**KIRKLEES METROPOLITAN COUNCIL  
INVESTMENT & REGENERATION SERVICE**

**DELEGATED DECISION TO DETERMINE PLANNING APPLICATIONS**

Reference No:	<b>2025/62/91980/E</b>
Site Address:	11, Manor Farm Drive, Soothill, Batley, WF17 6HE
Description:	Erection of front dormer and associated alterations
Recommending Officer:	Jennifer Booth

## **OFFICER REPORT**

Issue Purpose : HH Application		
Project	Proposed front dormer window	Date 10-07-2025
		Scale 1:100 @ A3
Address	11 Manor Farm Drive, Batley, WF17 6HE	Proposal
		D.N. 2025 - 11MFD - 03

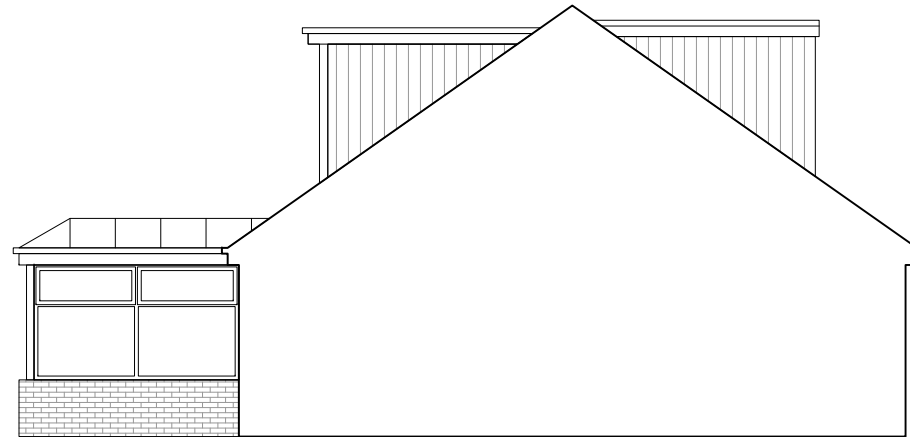
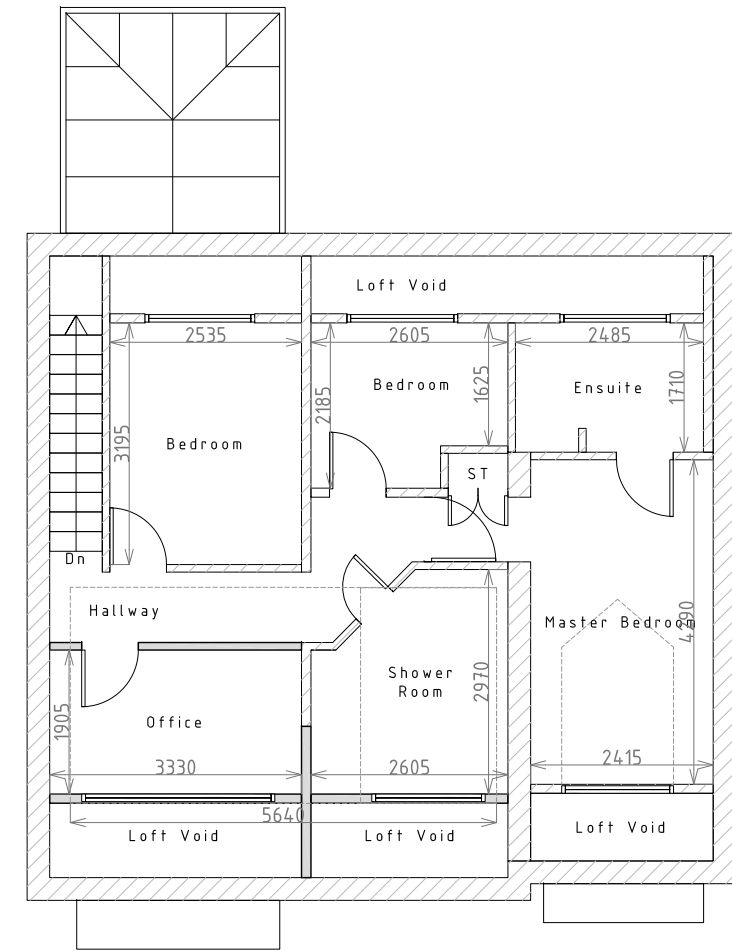
The initially proposed scheme proposed one large front dormer which would have been out of character with the host property and wider area. Amended plans have been sought which reduced the scheme to two smaller dormers. As the alteration reduced the level of development, the amended plans have not been advertised.

Issue Purpose : HH Application			
Project	Proposed front dormer window	Date	10-07-2025
		Scale	1:100 @ A3
Address	11 Manor Farm Drive, Batley, WF17 6HE	Proposal	
		D.N.	2025 - 10MFD - 03 - A

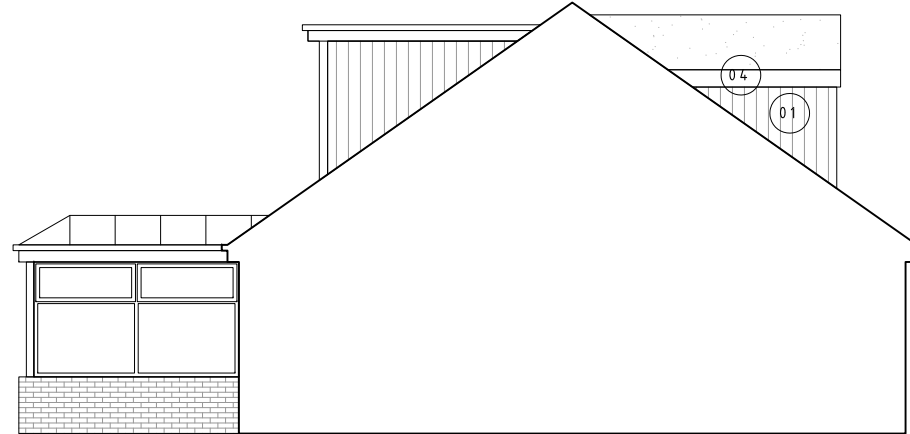
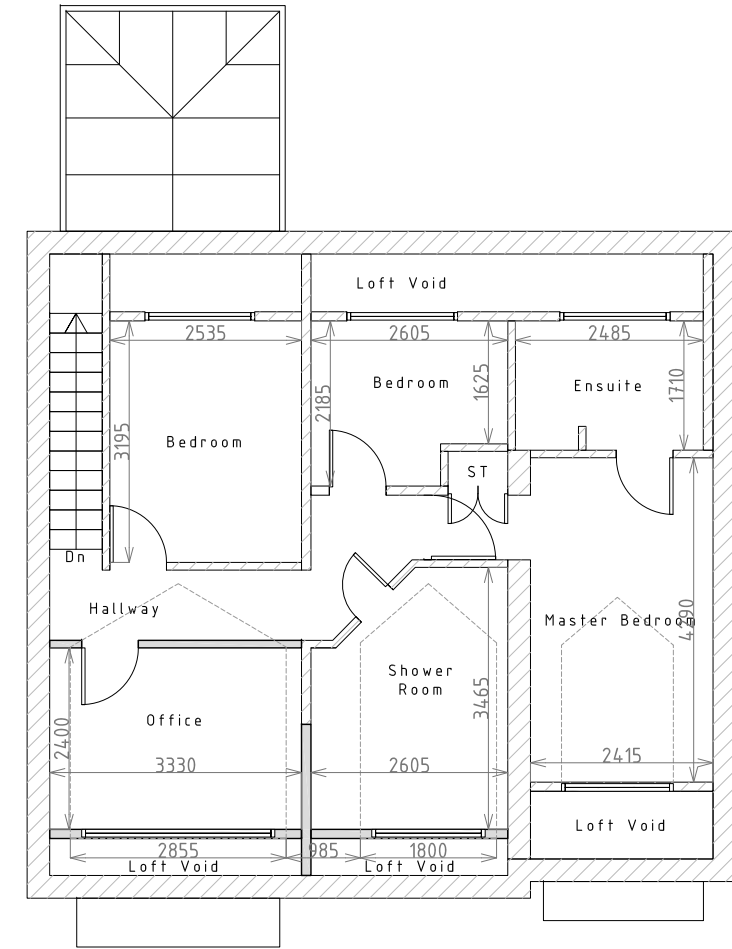
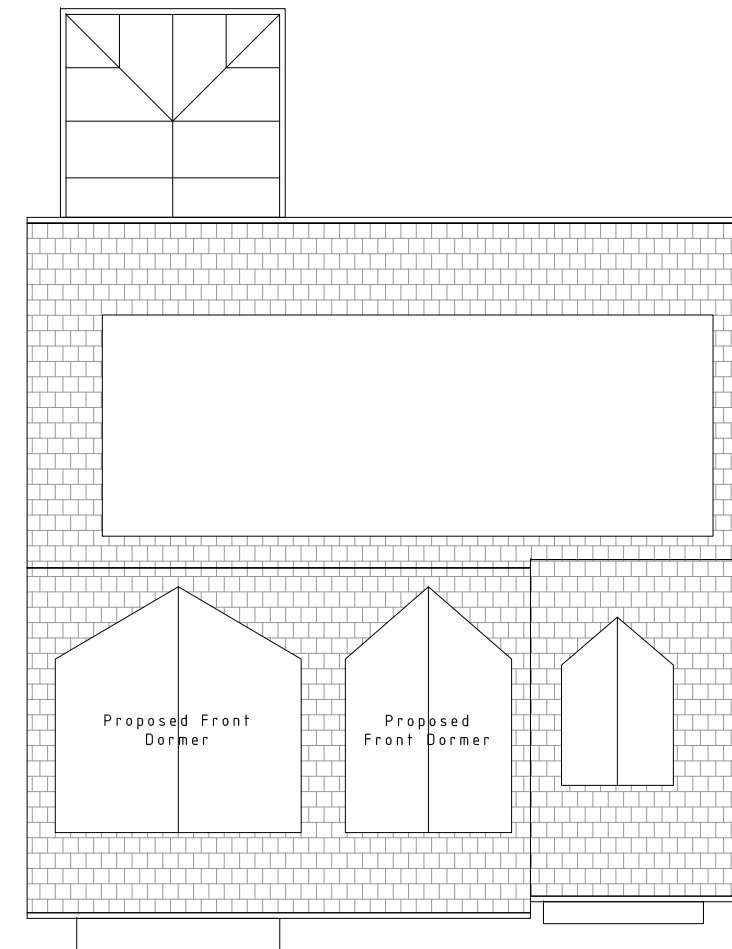
The first dormer would have a width of 2.8m with a maximum height of 2.2m. The roof form would be pitched.

The second dormer would have a lesser width of 1.8m with a matching height of 2.2m. The roof form would be pitched.

The dormer face and cheeks would be clad with grey timber cladding.

The scheme has been amended during the course of the application and now includes two front-facing dormers. The larger dormer is positioned above the principal front window, while a smaller dormer is located above the front door. The variation in size is considered acceptable, as it establishes a proportional and visually coherent relationship with the fenestration below. The use of dark grey cladding, in combination with matching roof tiles and a pitched roof design, ensures that the original roof form remains legible and contributes positively to the overall appearance of the dwelling.
